DEVELOPMENT REVIEW BOARD
TRANSPORTATION DEVELOPMENT

DRB Project Number: 1006865
Carpenters Training Center

SUBJECT: Site Plan for Building Permit

DATE: April 4, 2018

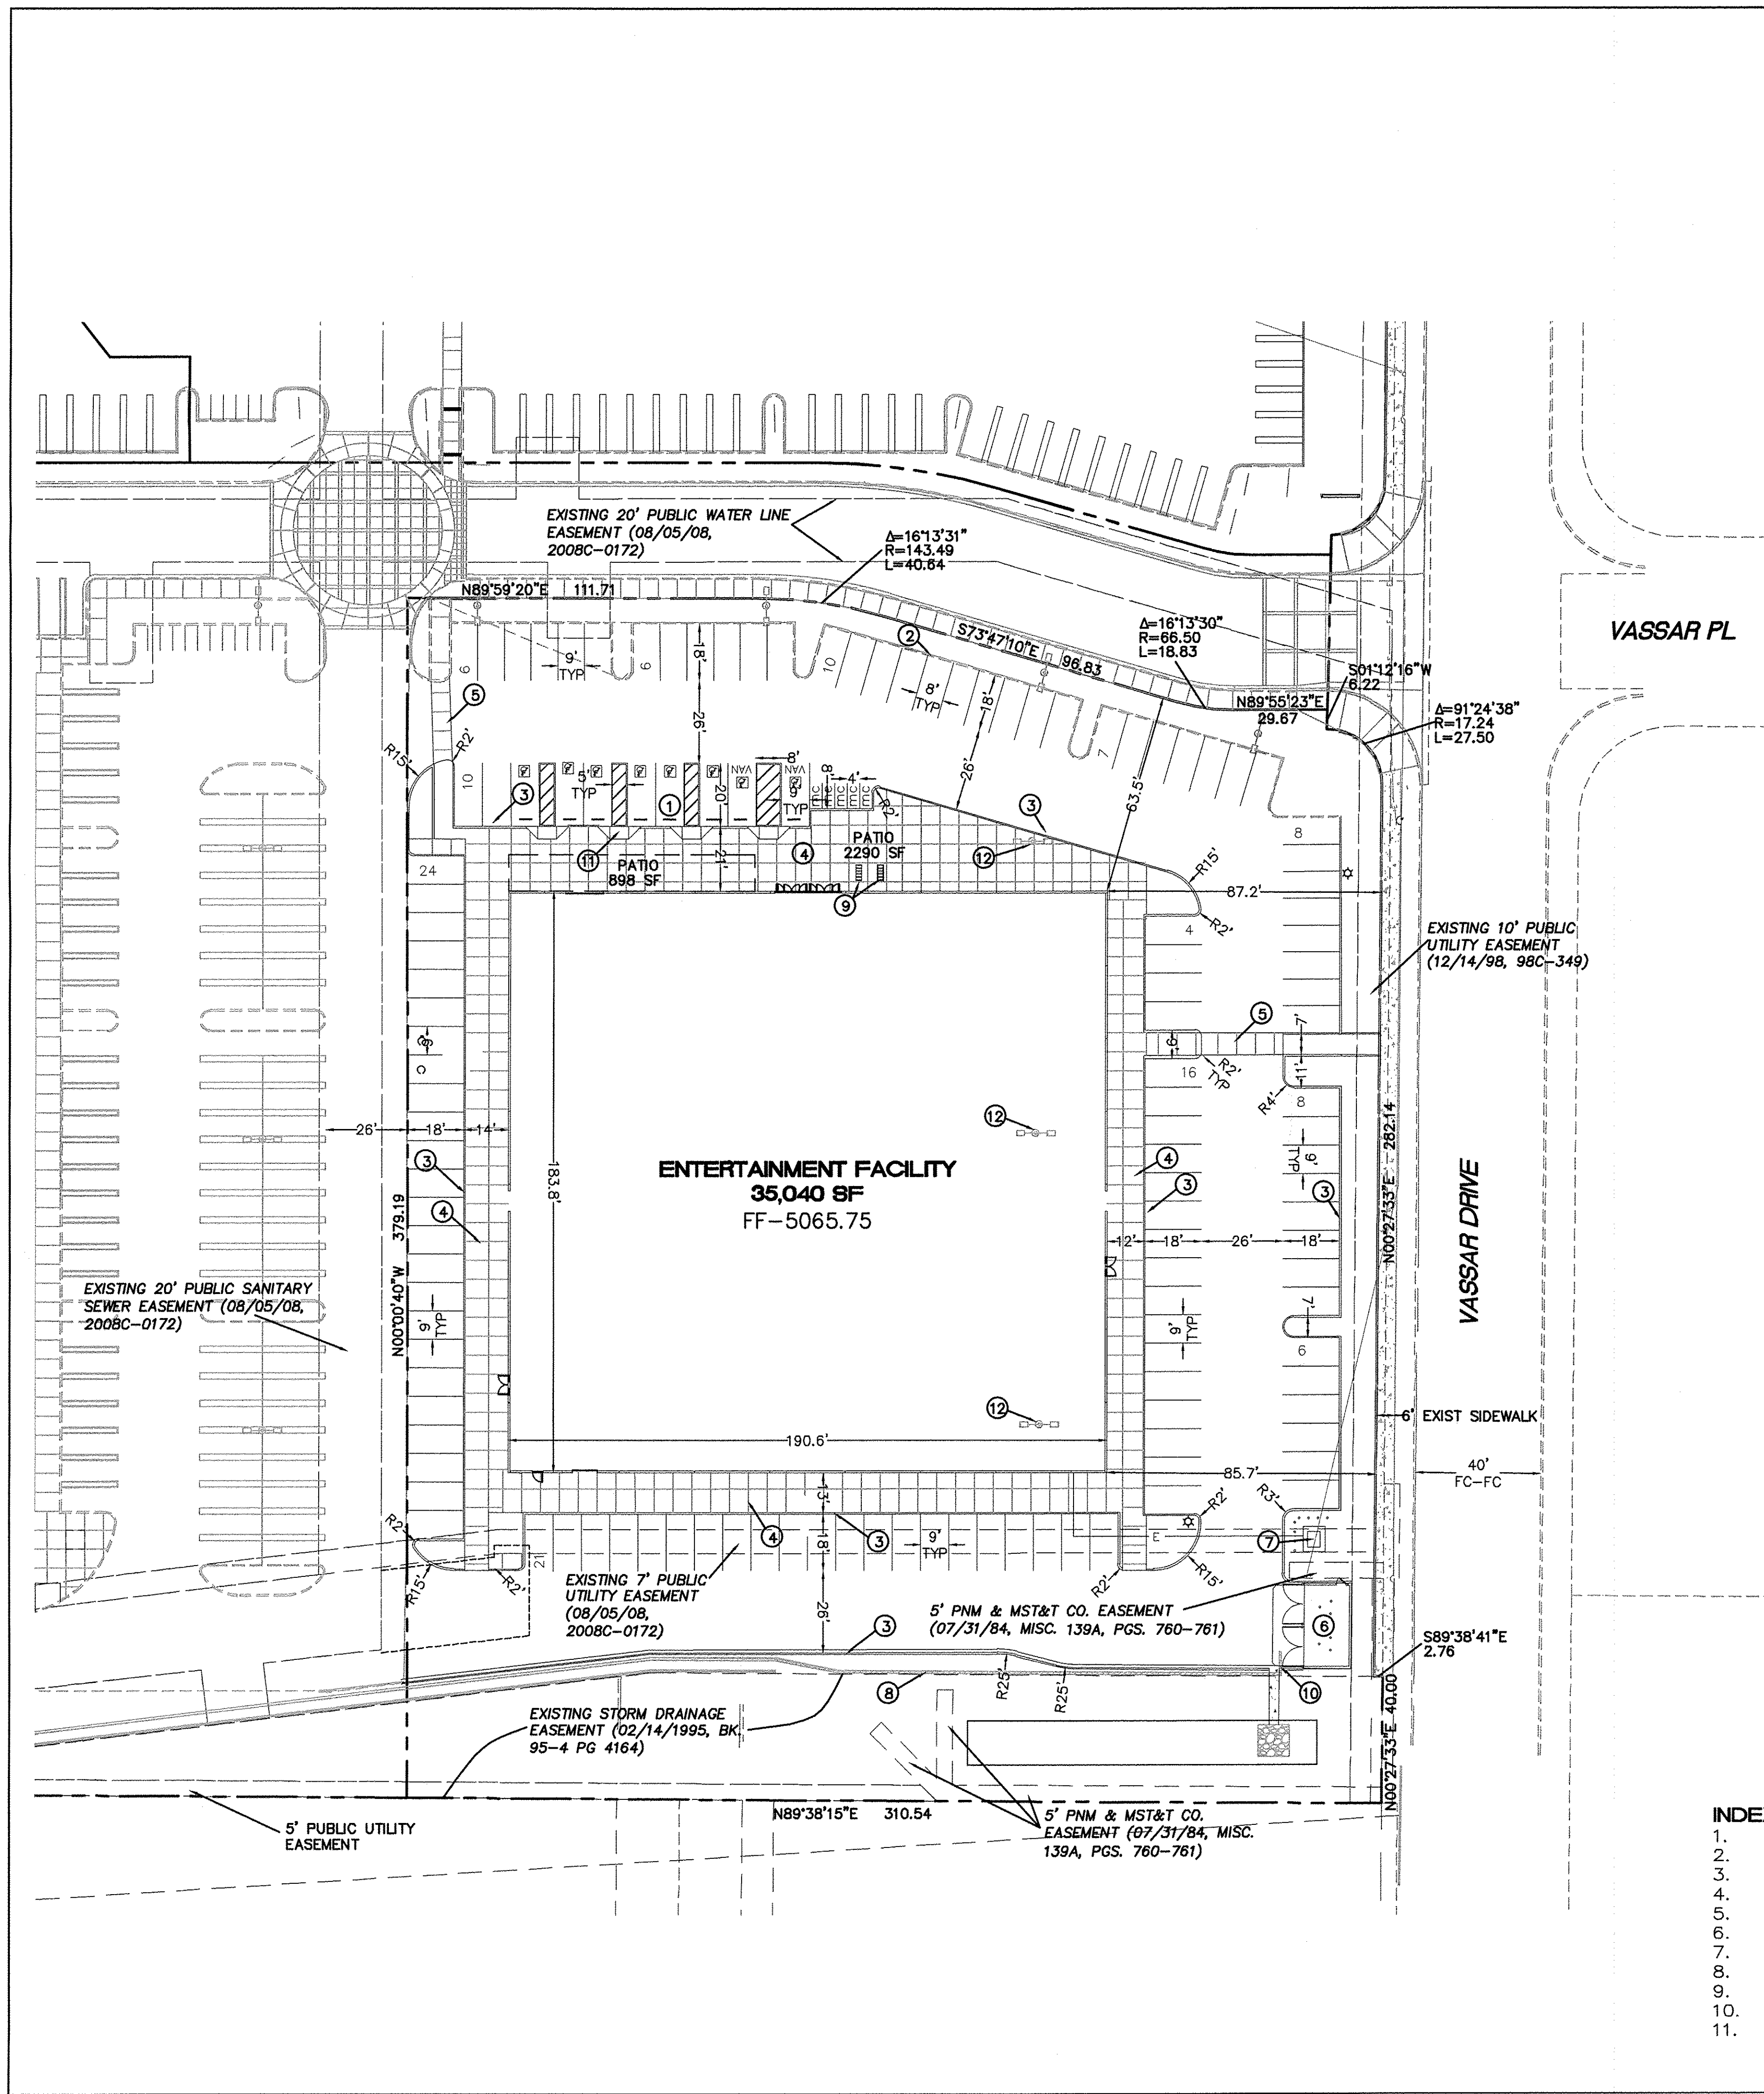
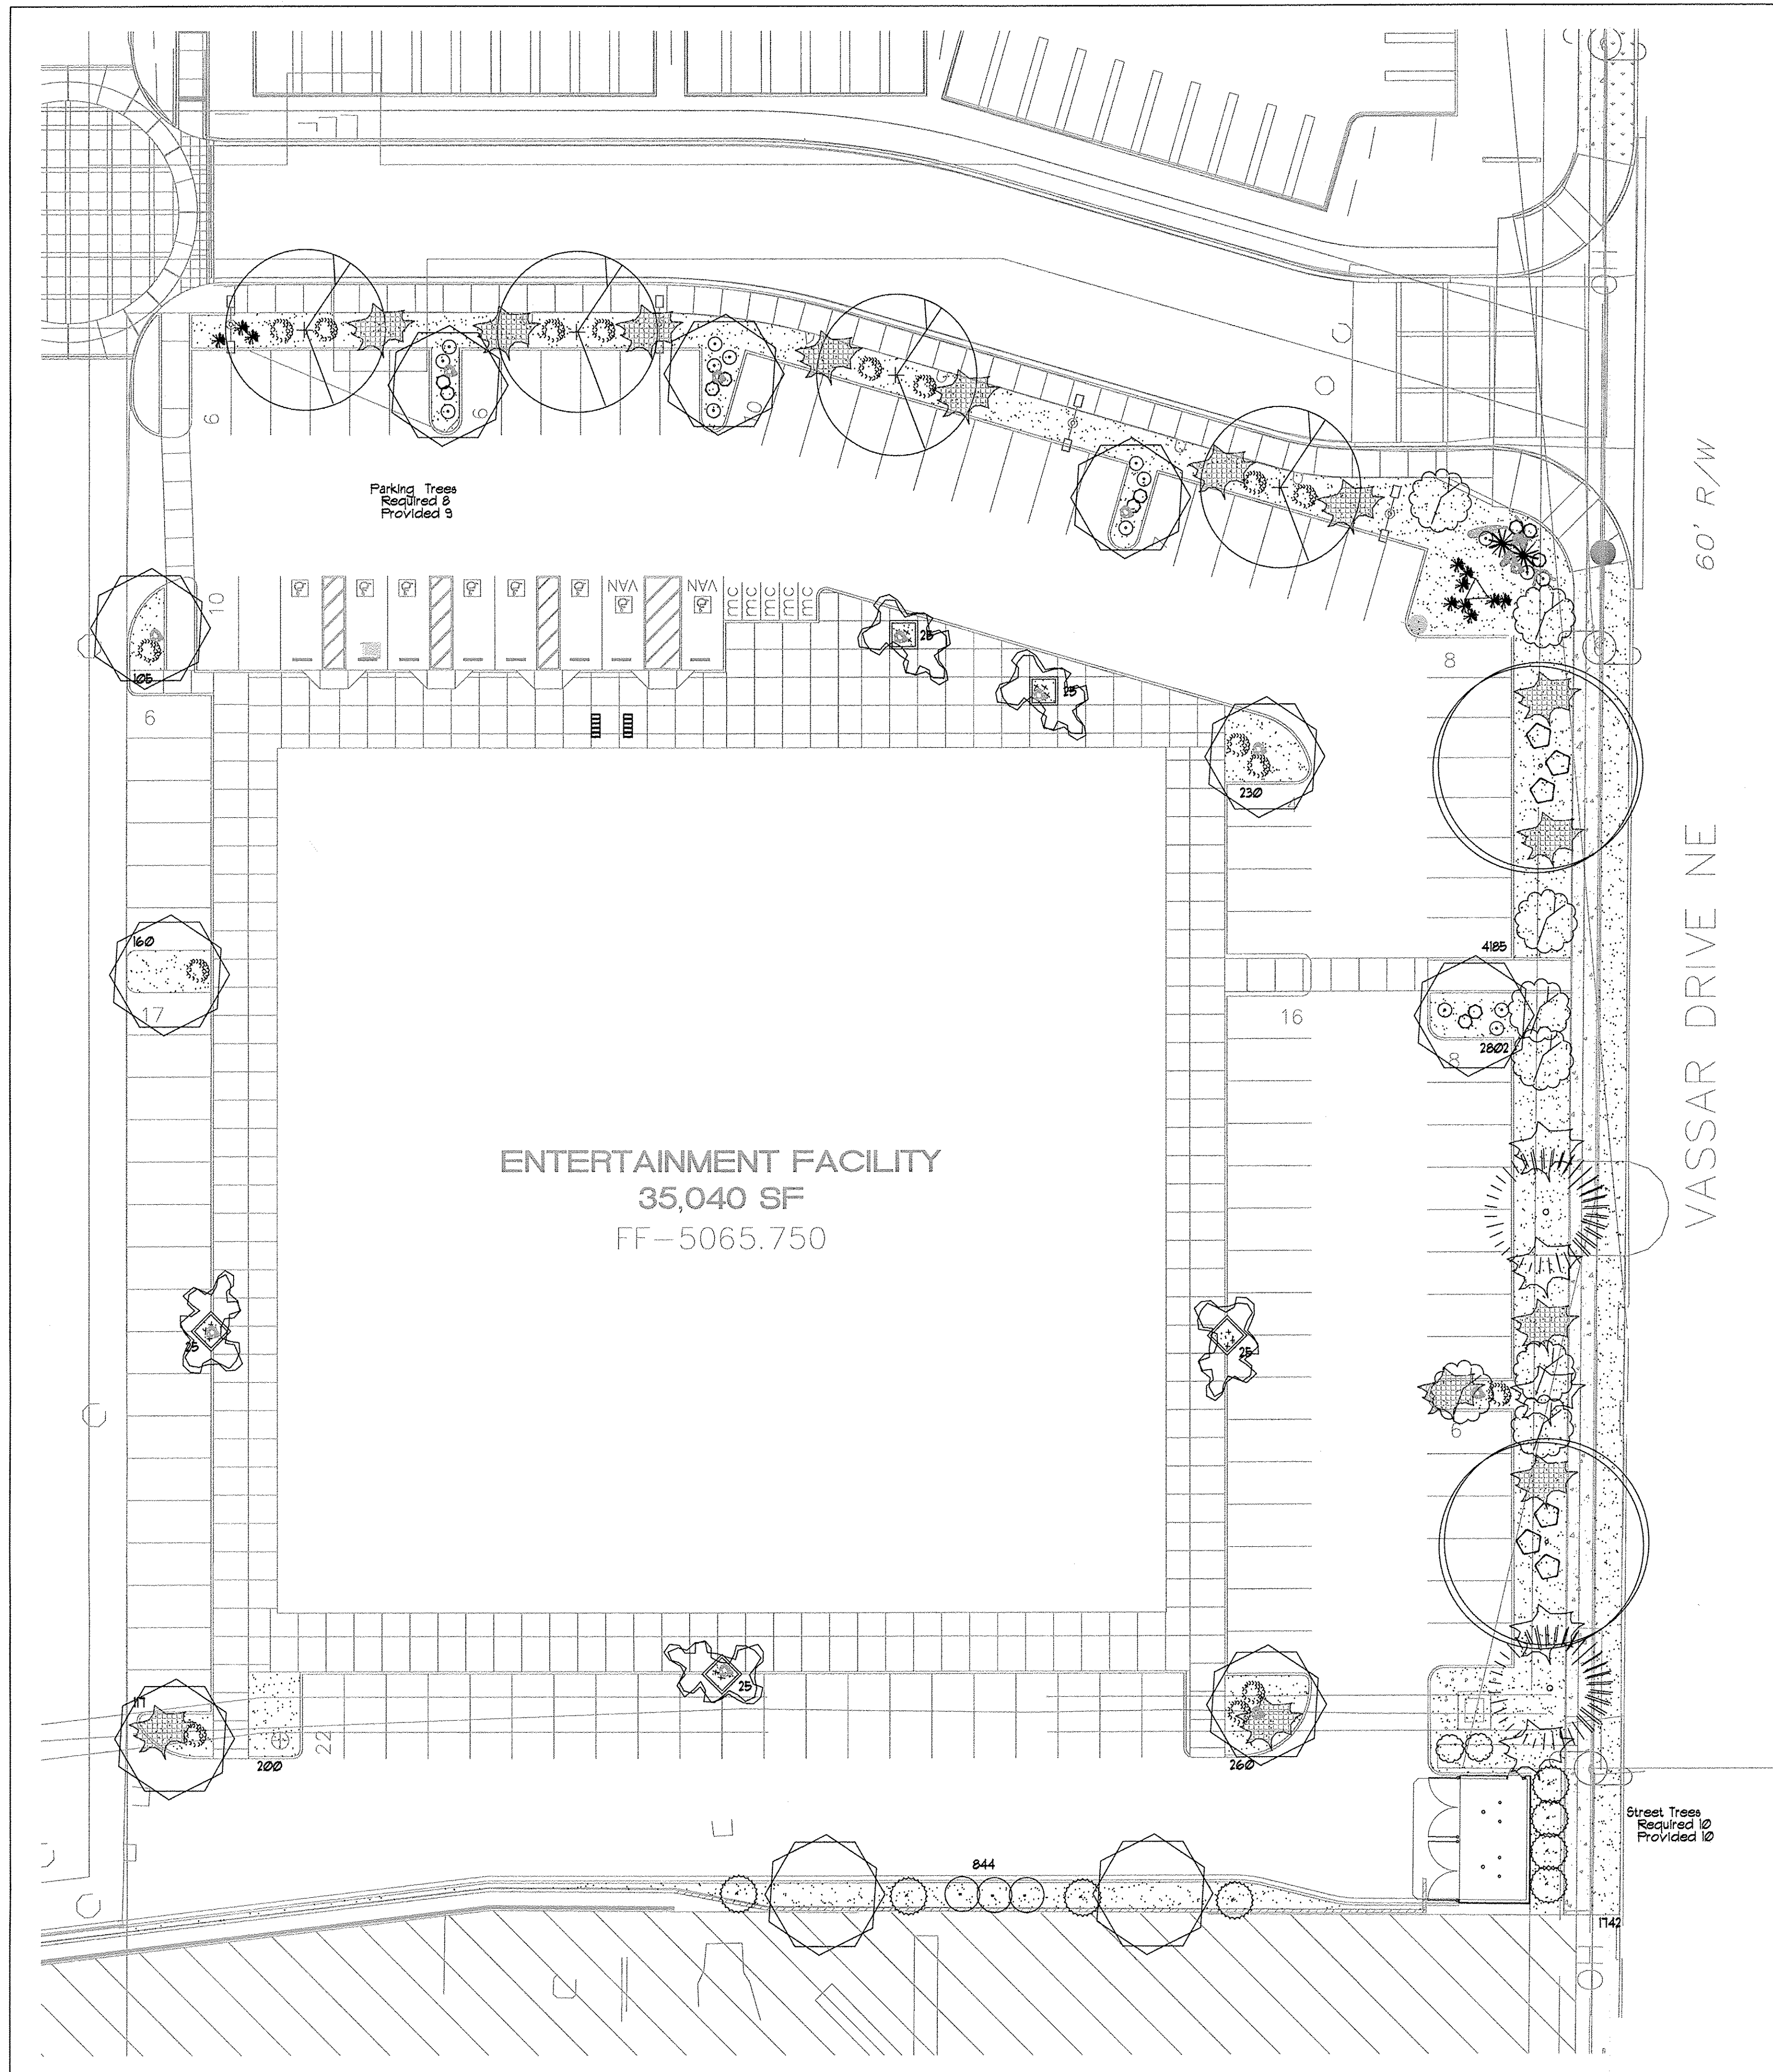
1. Motorcycle parking spaces shall be designated by its own conspicuously posted upright sign, either free-standing or wall mounted per the zoning code. (Add Keyed note showing location of sign on site plan)
